RE: Review Comments for Final Plan – Administrative Review

Project Name: Riverside Wood/Millwork Shop
Project ID: 10-79900010
Project Address: 828 Riverside St CBL: 325-B-008-001
Planner: Erick Giles, AICP, LEED AP

2 SITE PLAN
SCALE: 1" = 10'

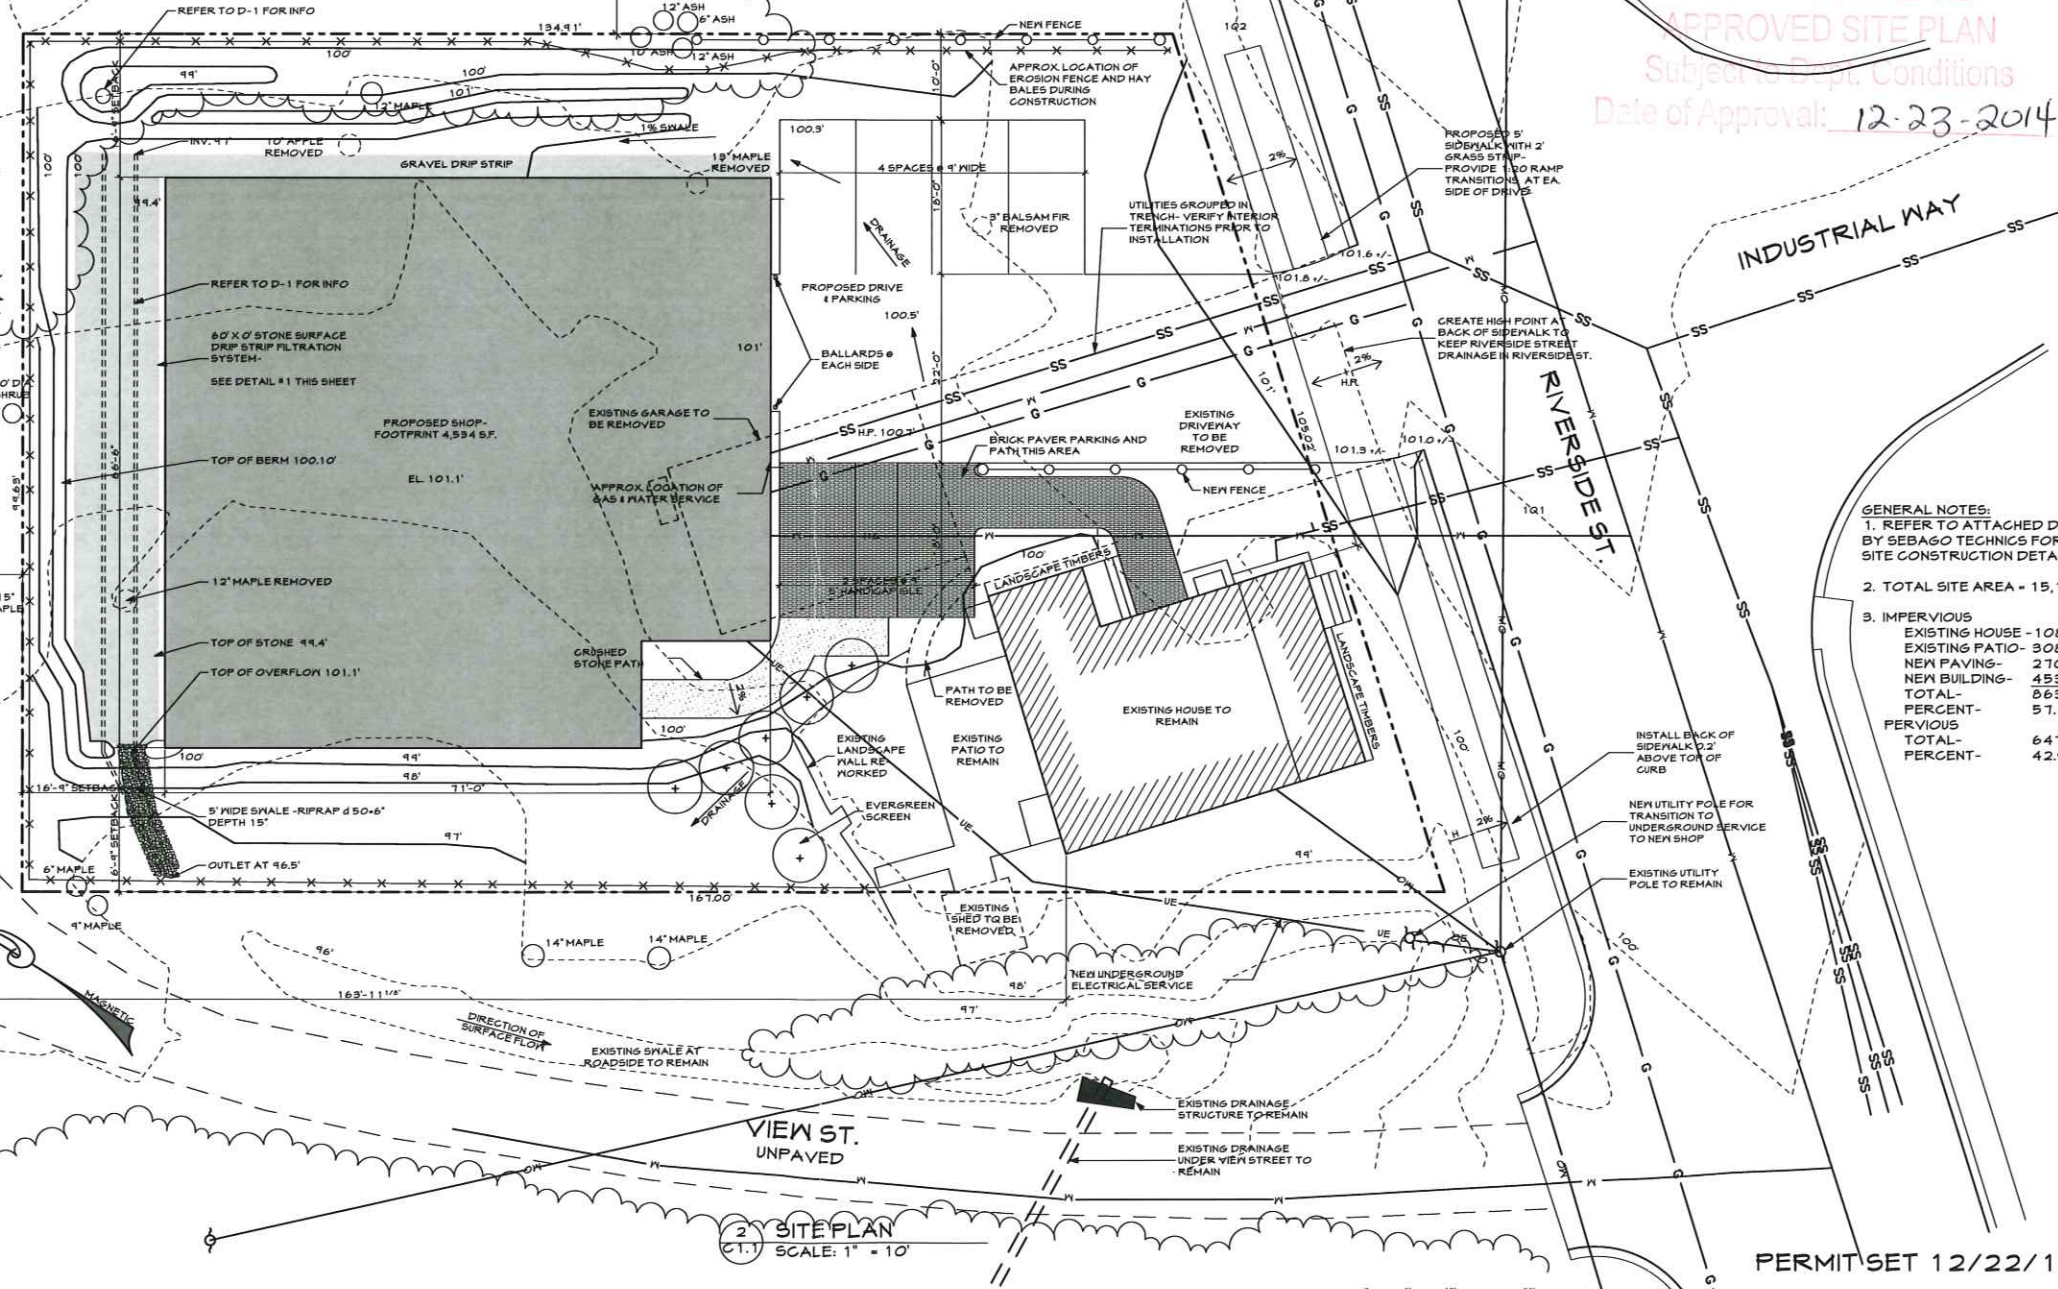
- i. Applicant needs to apply for a sidewalk waiver if they do not intend to install a sidewalk.
- ii. Applicant current shows an approximate 10' x 10' shed within the View Street R-O-W. Applicant shall indicate that this shed will be moved onto the applicant's property within the required 10' setback line.
- iii. Applicant indicates the existing 25' wide driveway will be removed and replaced with a 20' wide driveway. Does the applicant intend to alter the curb cut to the street?
- iv. The applicant is requested to show how drainage from the site will be handled.
